**To Kittitas County, Planning Dept.
SEPA Conditional Use Permit – Use Change Application
Project Name: Apostolic Faith United
Project No. CU-22-00001**

SITE PLAN
WALTER DAVENPORT
(17-19-08055-0002)
SCALE: 1" = 120'

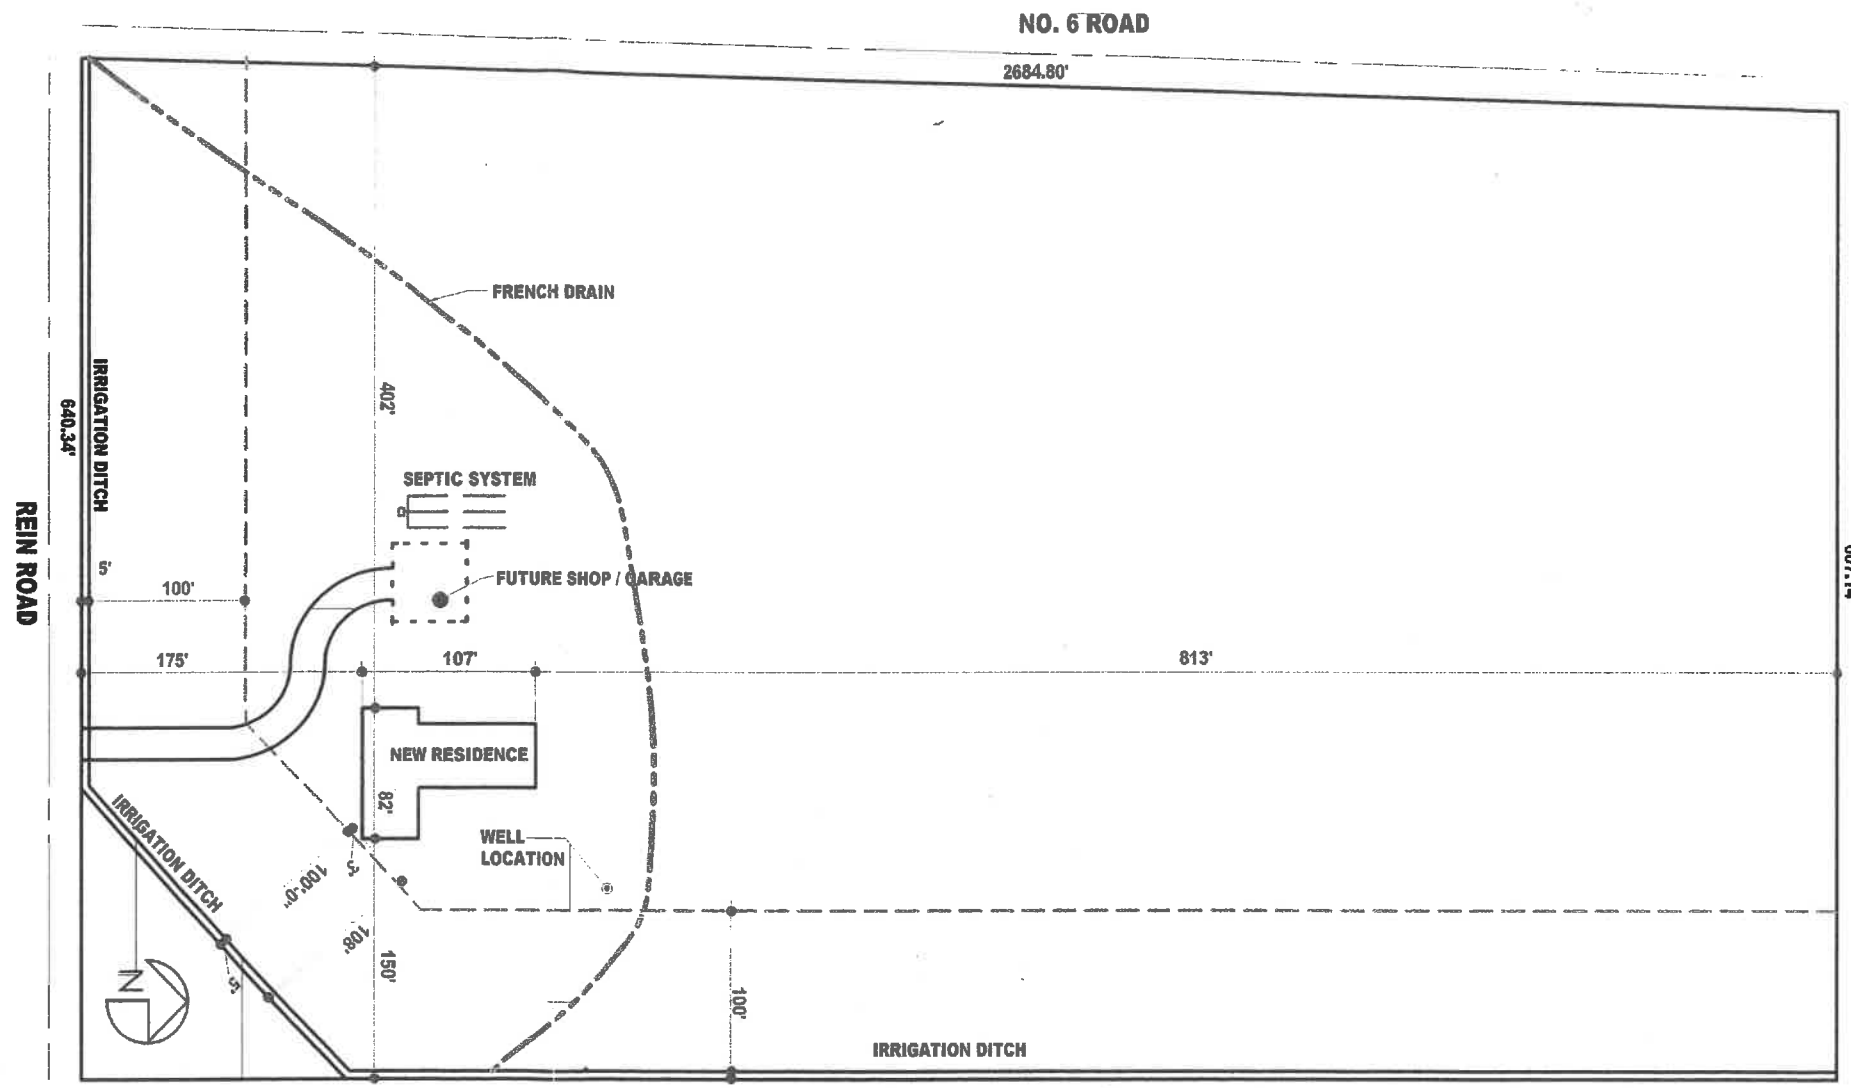
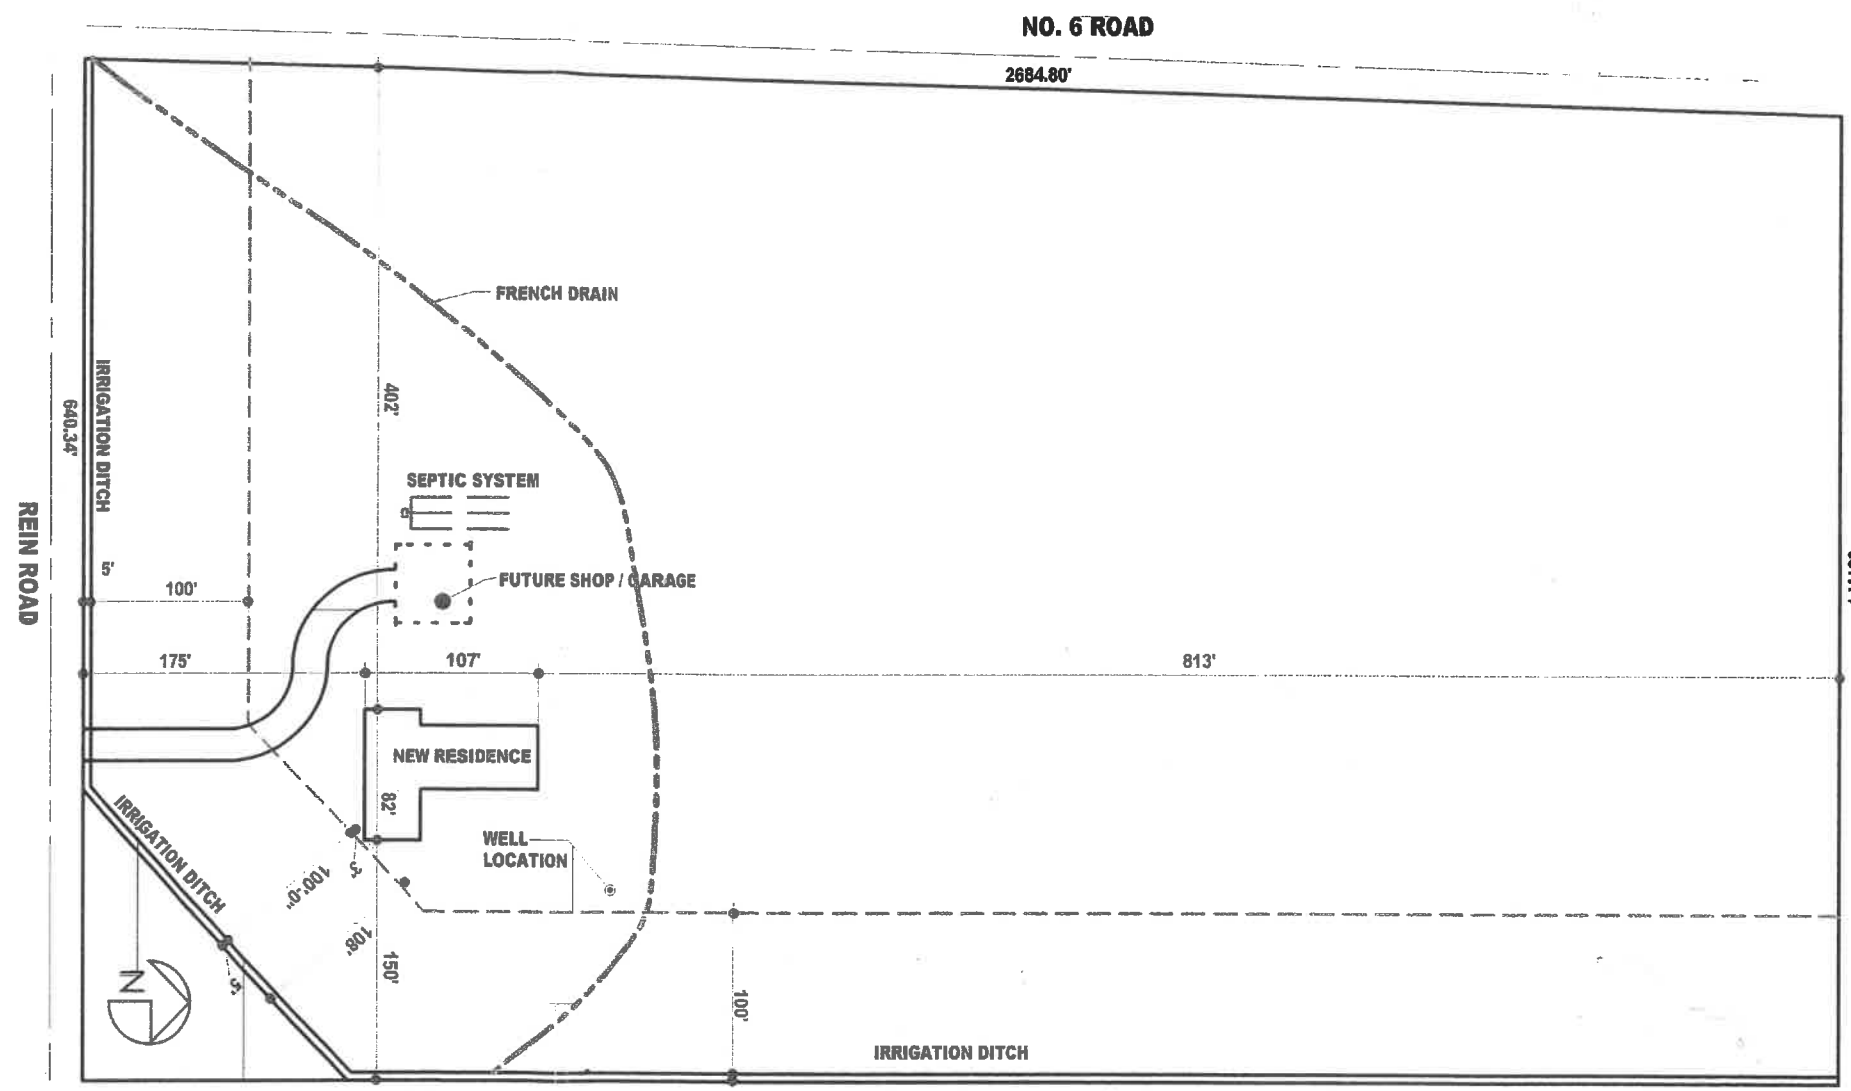
- 7) The SEPA Checklist under Section 3.c.1, does not describe the water runoff from the asphalt or roof as impervious surfaces. Is a stormwater runoff plan needed, as would be typical for any commercial business, before development would be allowed? Will the parking lot need expanded to accommodate 80 cars?

- 9) The SEPA Checklist under Section 7.a.4, should outline how emergency service use may be needed as an additional 80 parishioners who will attend church services, as fire or health services may be needed. What about defined ingress/egress to the site, required fire connections (for commercial use), and route? The current access is not acceptable. Will a better access plan, to accommodate the growth, be required?

- 19) Section 14 was not completed and needs to address impacts to Rein Road and Road No. 6.
- 20) Under Section 14.h, I would like to see mitigation measures required for the increased use from this site, along with whatever other uses the county may permit under the conditional use permit. If this is permitted for commercial church activities, I would like to see the county require a turn out for traffic be established off Road No. 6. Signage for the church could be seen, and access turn outs, and perhaps sidewalks, wide enough to accommodate the additional use. My biggest objection to this site (and proposed use), is the additional traffic (going on now), and having a plan that accounts for all the noise all times of day and night.
